Concept Development Application (Staged Development) for Alterations and Additions to the InterContinental Hotel and Transport House, Sydney (SSD 7693) – Amended Proposal

The Astor is a heritage listed residential apartment building constructed in 1923. It contains 52 apartments and is situated on the western side of Macquarie Street between Bent Street and Phillip Lane.

SETBACK DIAGRAM | VIEW FROM NORTH-EAST

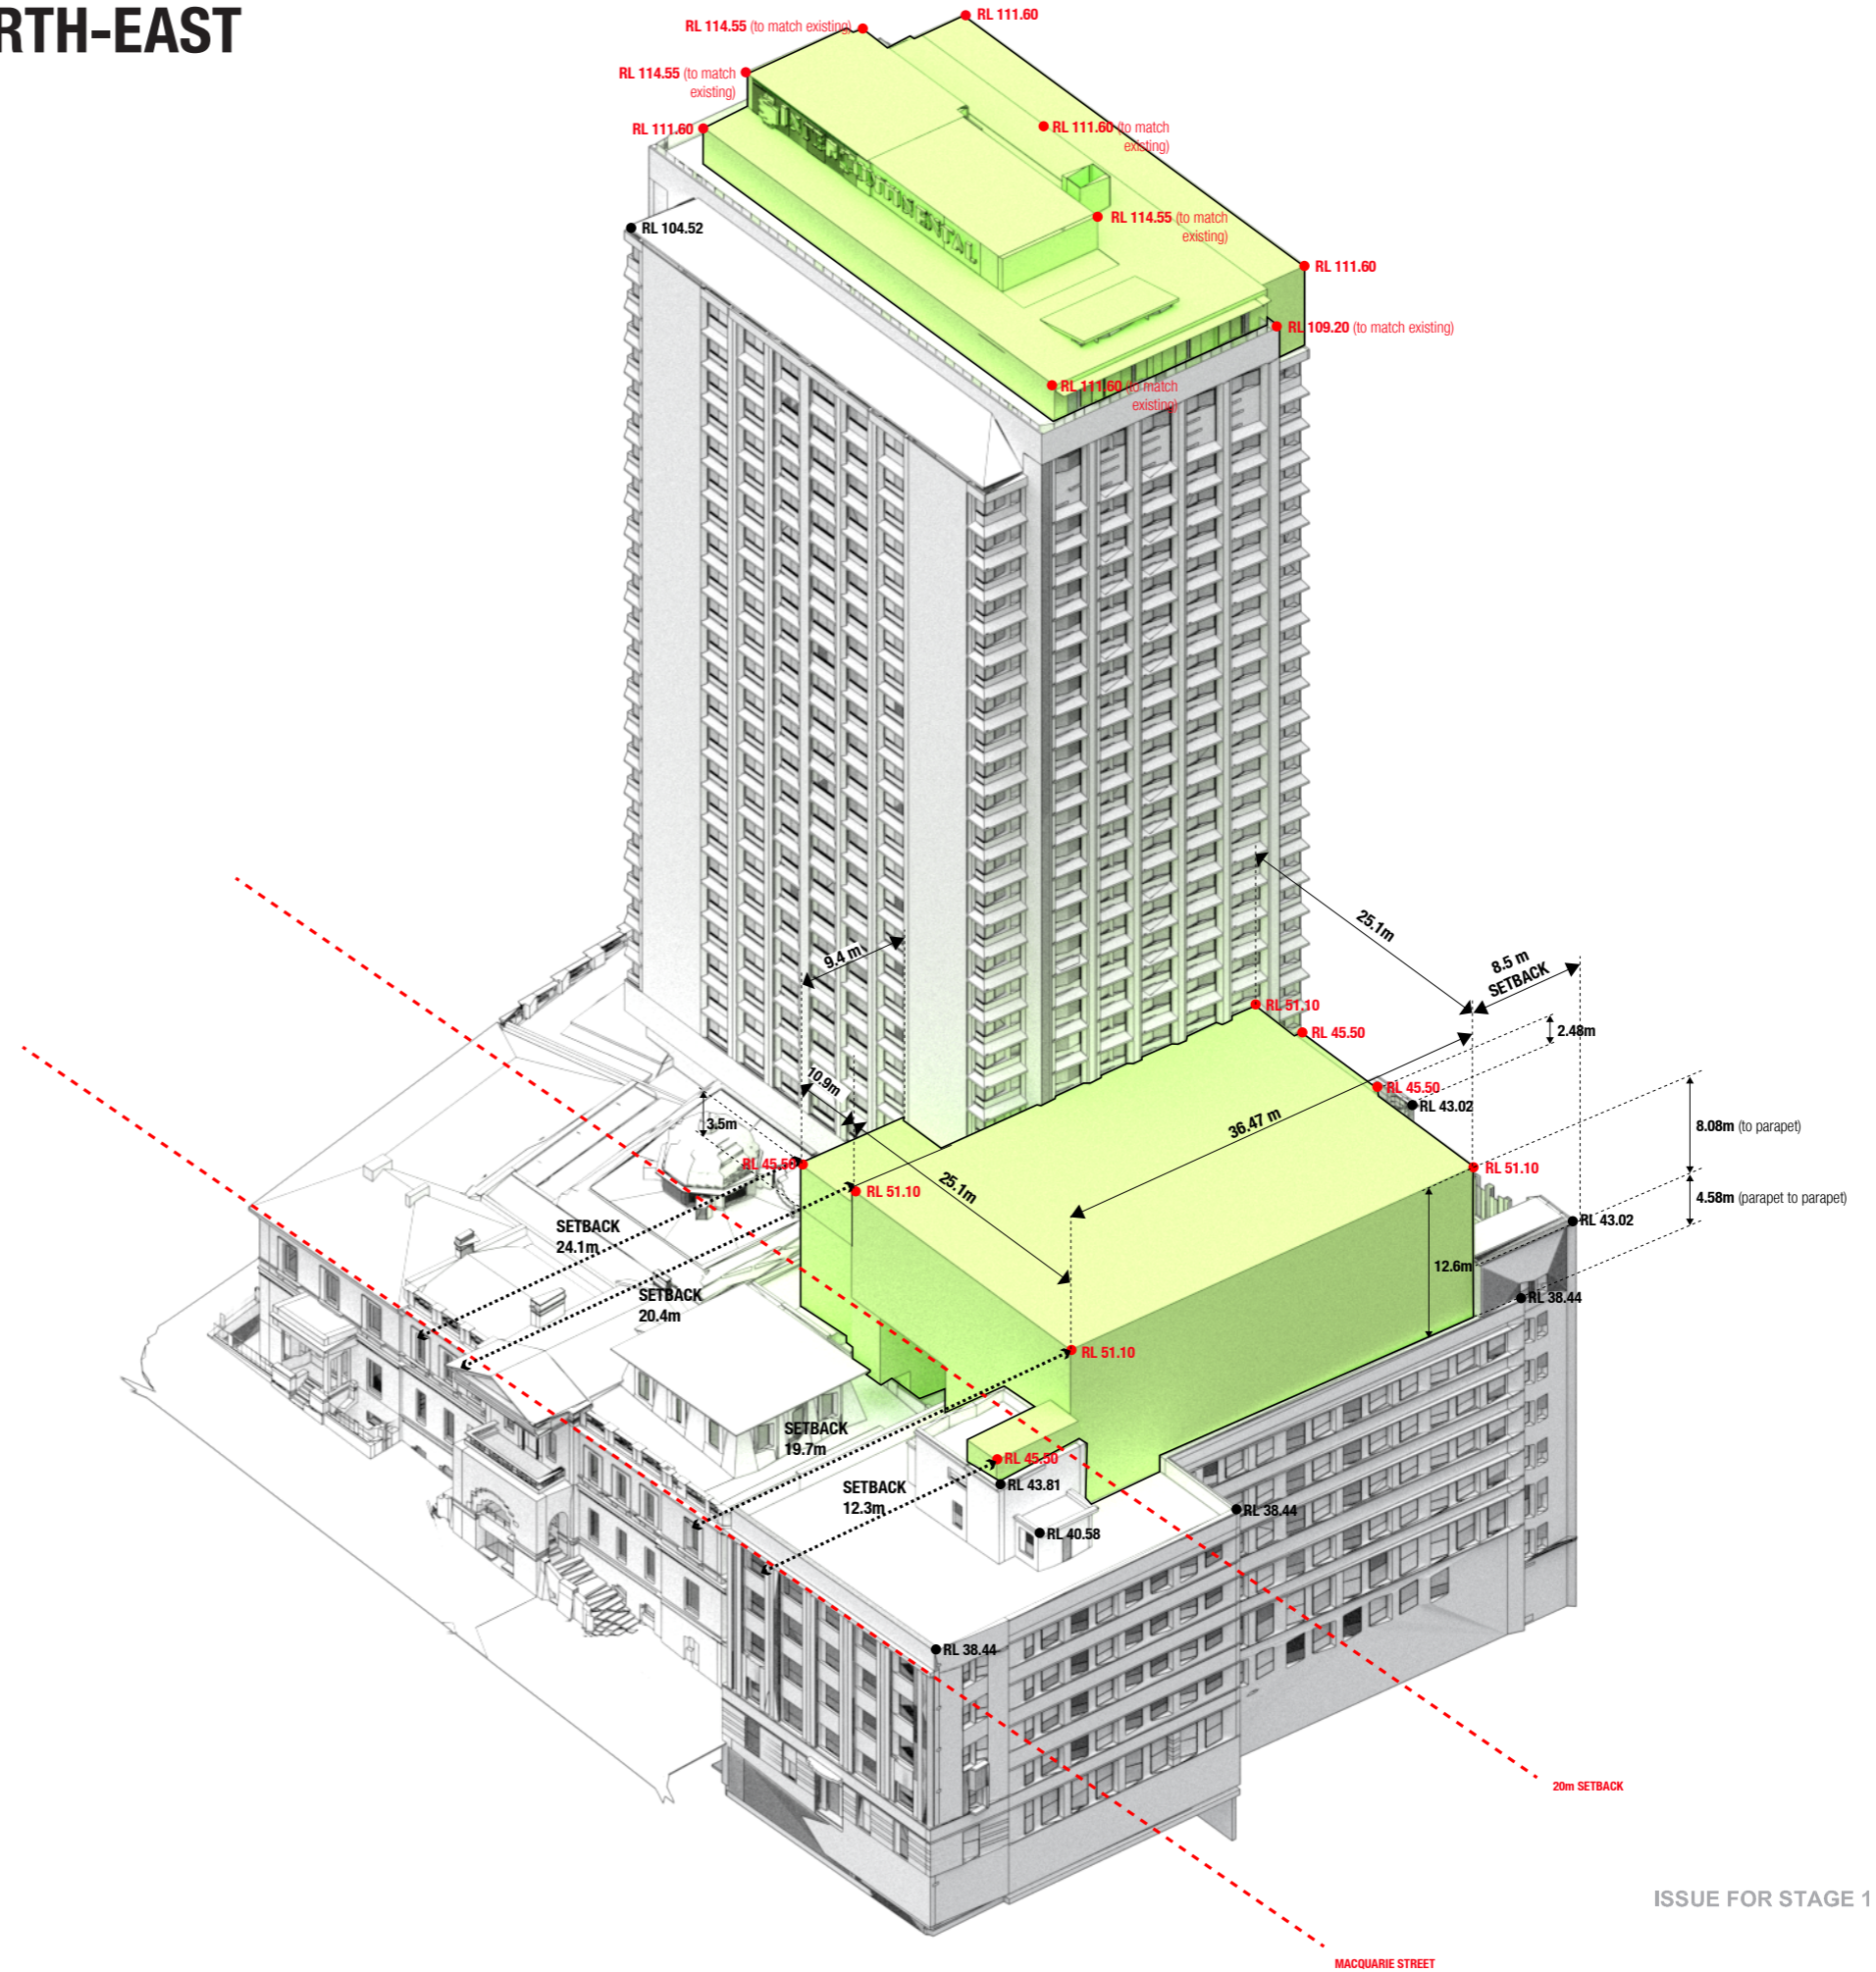
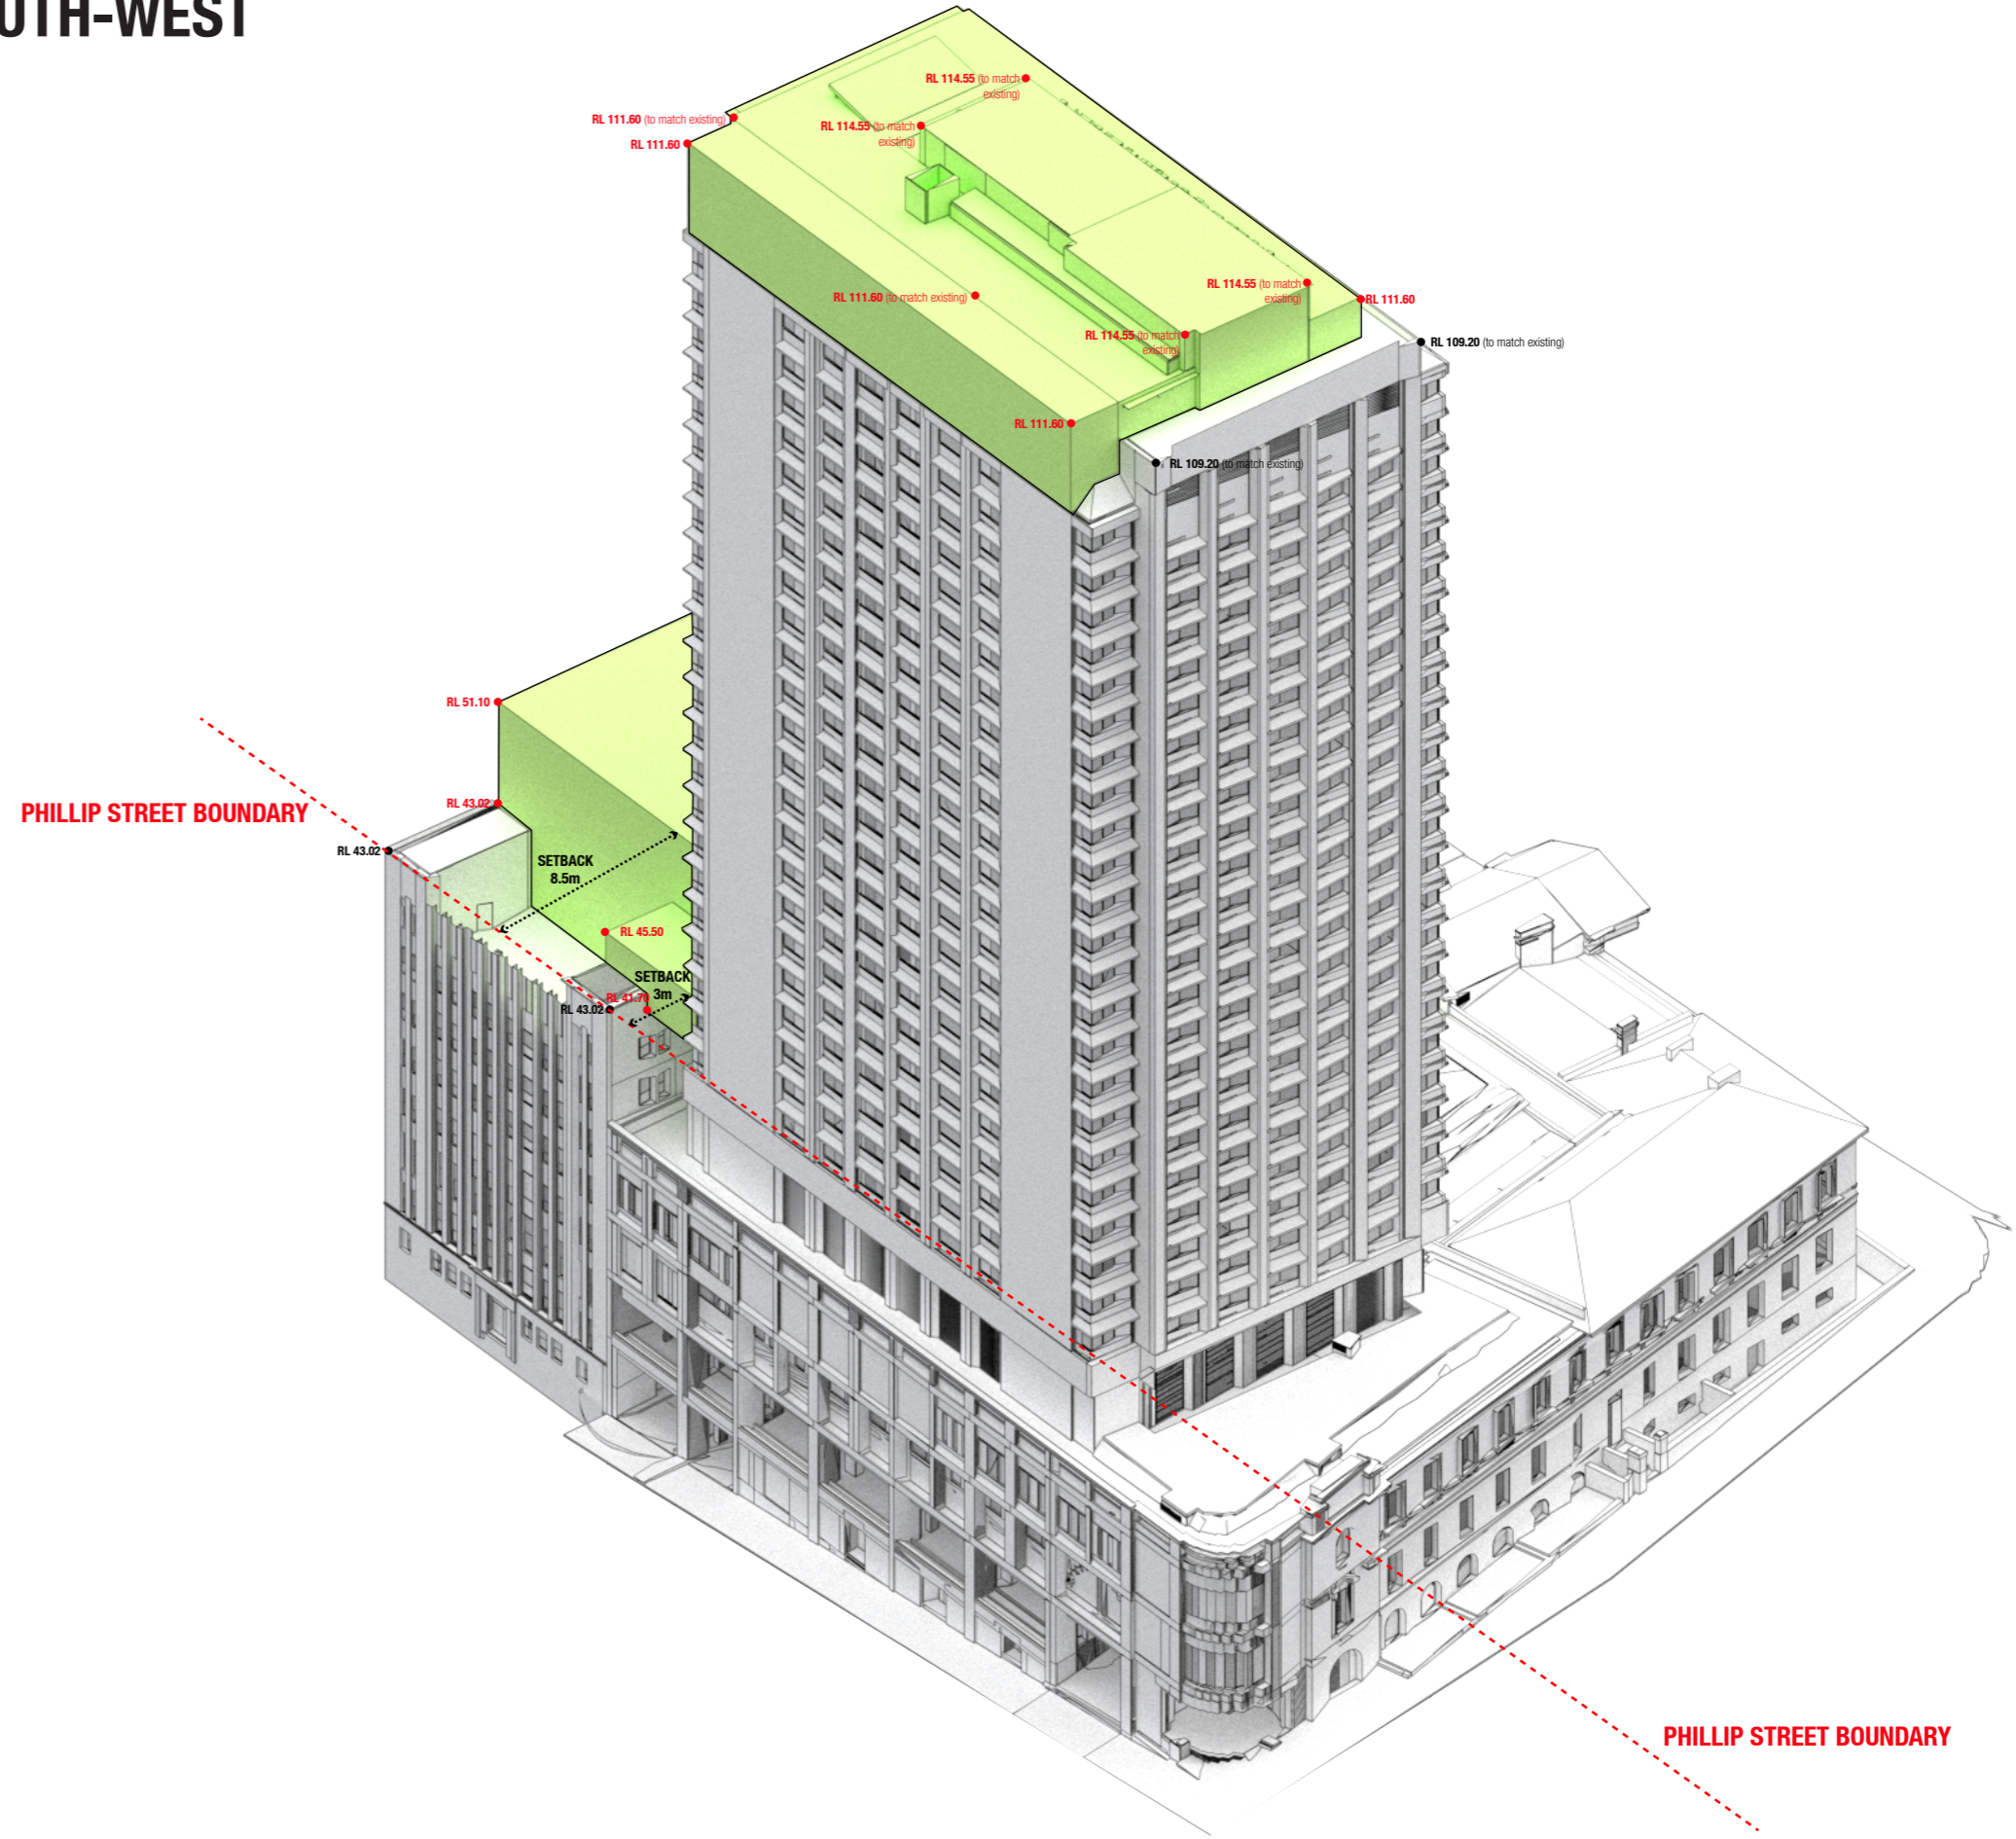
Specifically, the proposed development should comply with the 30 metre front setback control from Macquarie Street in the Special Character Area.

To not comply with existing setbacks will overwhelm and detract both from the heritage buildings on which the proposed building envelope sits, and generally, the heritage streetscapes in the Macquarie Street Special Character Area.

1. The impact only occurs because the proposal does not comply with the requirement of the Development Control Plan for a 30 metre setback from Macquarie Street. There is no public benefit from the reduced setback – and arguably there is a public detriment in terms of adverse heritage impacts.
2. The InterContinental has already taken away iconic views of the Harbour Bridge from The Astor. To continue to allow for views from The Astor to be "nibbled" away by this proposed development is inequitable.
